# Rezoning Transportation Analysis

Petition Number: #2021-277

## Revision Log:

Date	Description
05-18-2022	First Review (WB)
09-21-2022	Second Review (AO)

P:\2022 Jobs\20275 - Phil Aull Site - Smolin\CAD\Sketch Planning\20275 RZ_9-30-22.dwg

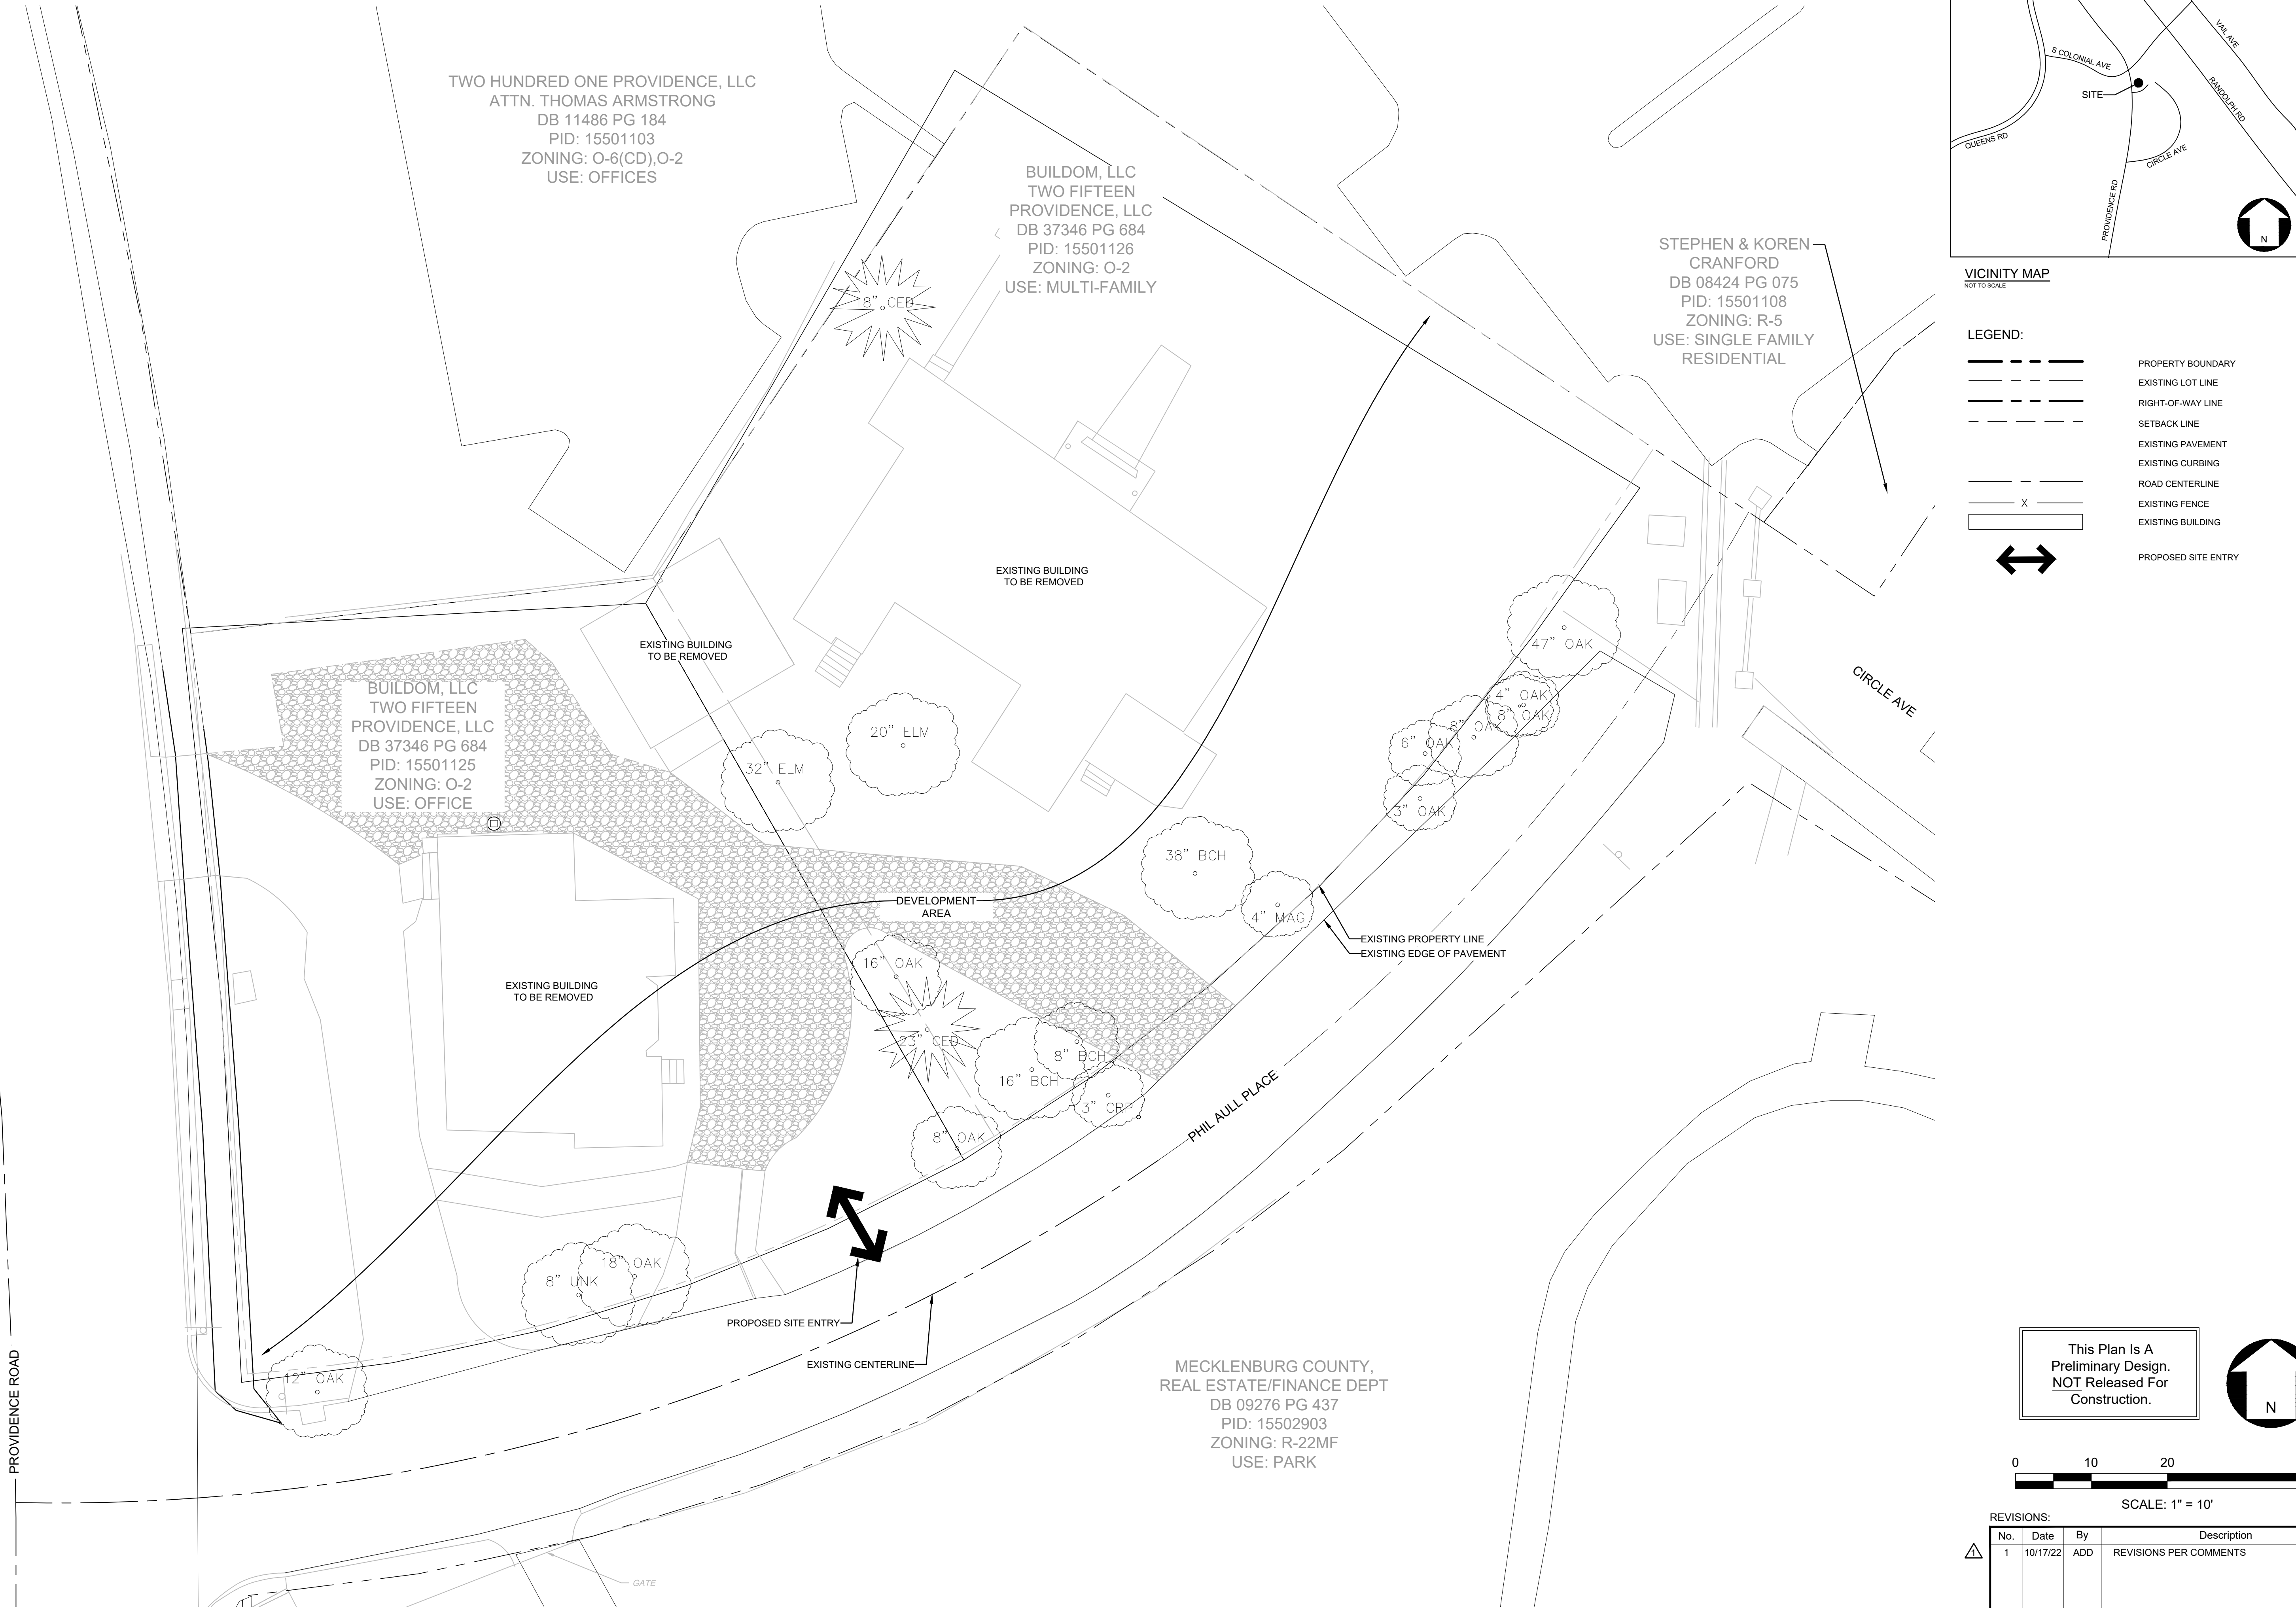
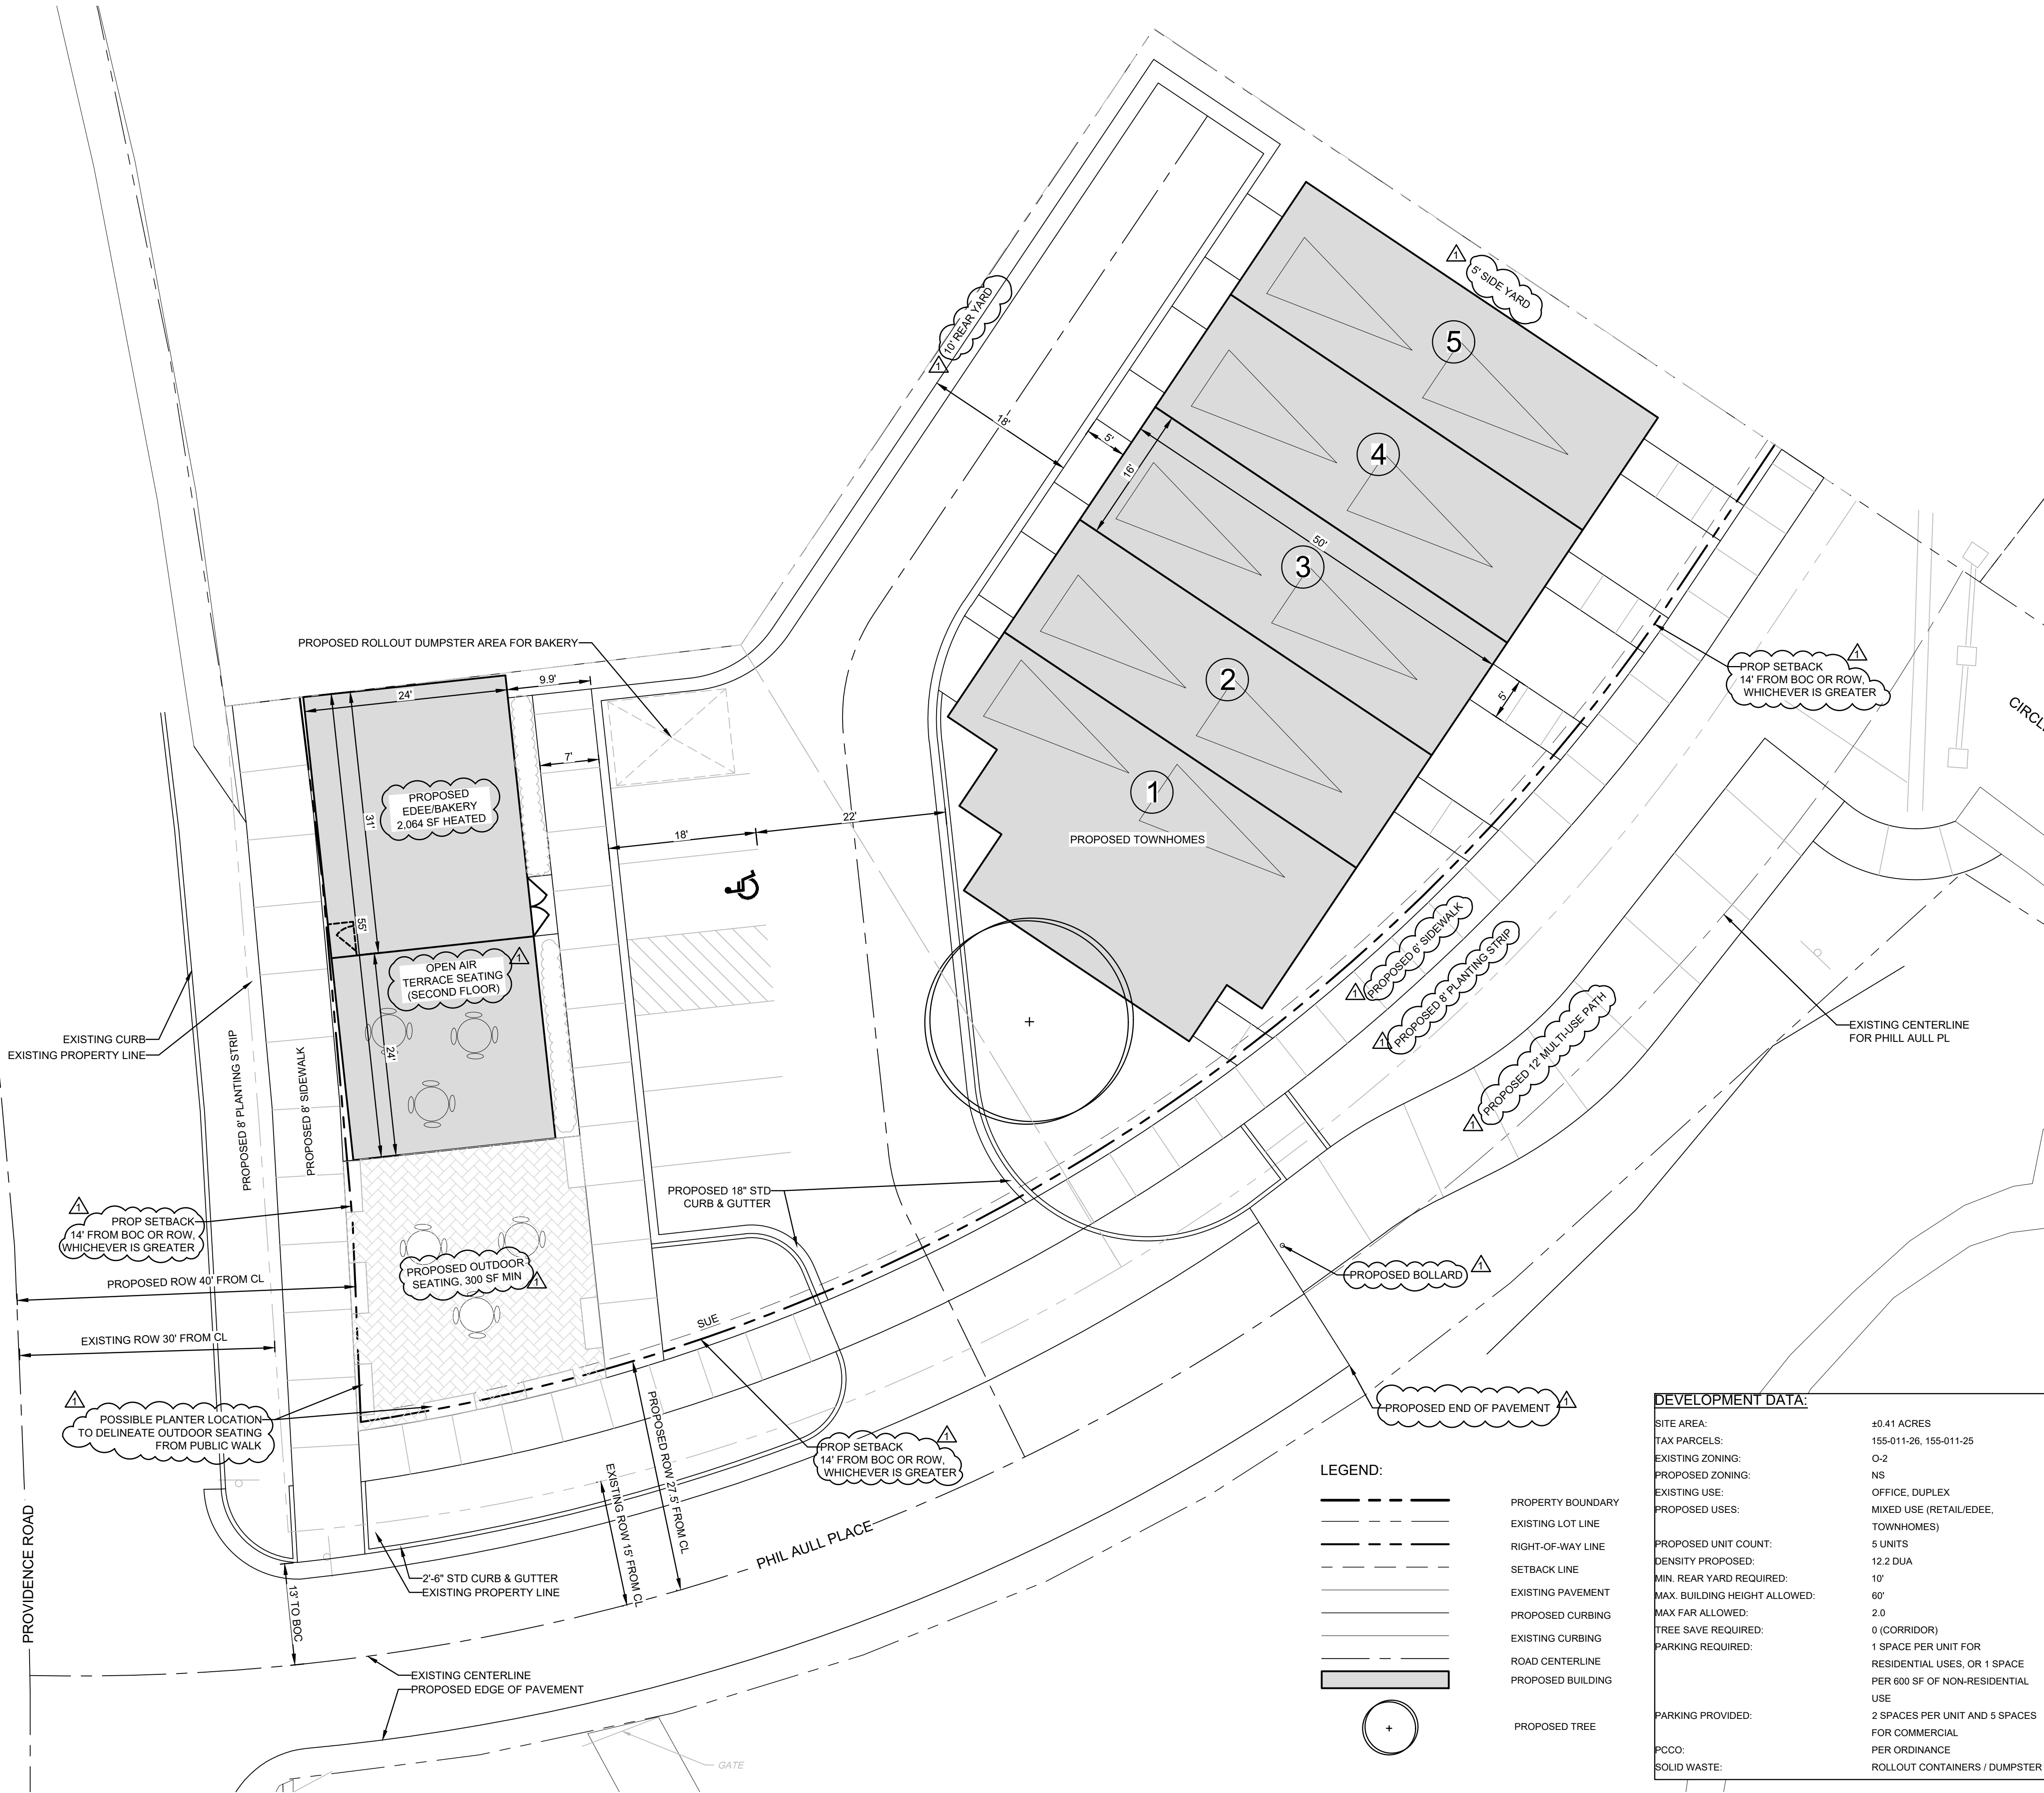
- Providence Road:** The future curb and gutter shall be located 32.5-ft from the centerline. This offset represents the future typical section of a 4+ Avenue with Buffered/Separated Bike Lanes. No relocation of the Curb & Gutter is required with this project; however, plans must label and dimension the future location.
- Phill Aull Place:** The future curb and gutter shall be located 20.5-ft from the centerline. This offset represents a Local Commercial Wide Typical section with on-street parking along the site's frontage.

Label and dimension the curb and gutter from the centerline for each road on the site plan.

### 3. **Outstanding Comment from 5-18-22:** Revise site plan and conditional notes to commit to dedicate 40-ft (min) right-of-way from the Providence Road centerline. Provide a sidewalk utility easement (SUE) 2-ft behind the future back of sidewalk (50.5-ft from the centerline). The site plan shall label and dimension the right-of-way from the road centerline.

### 4. **Outstanding Comment from 5-18-22:** Revise site plan and conditional notes to commit to dedicate 28.5-ft (min) right-of-way from the Phill Aull Place centerline per CLDSM U-05A. The site plan shall label and dimension the right-of-way from the road centerline. Site plan shows 27.5-ft from Phil Aull Place centerline.

6. **Outstanding Comment from 5-18-22:** Site plan and conditional notes revisions are needed to provide an ADA compliant pedestrian connection from Phill Aull Place to Circle Avenue.
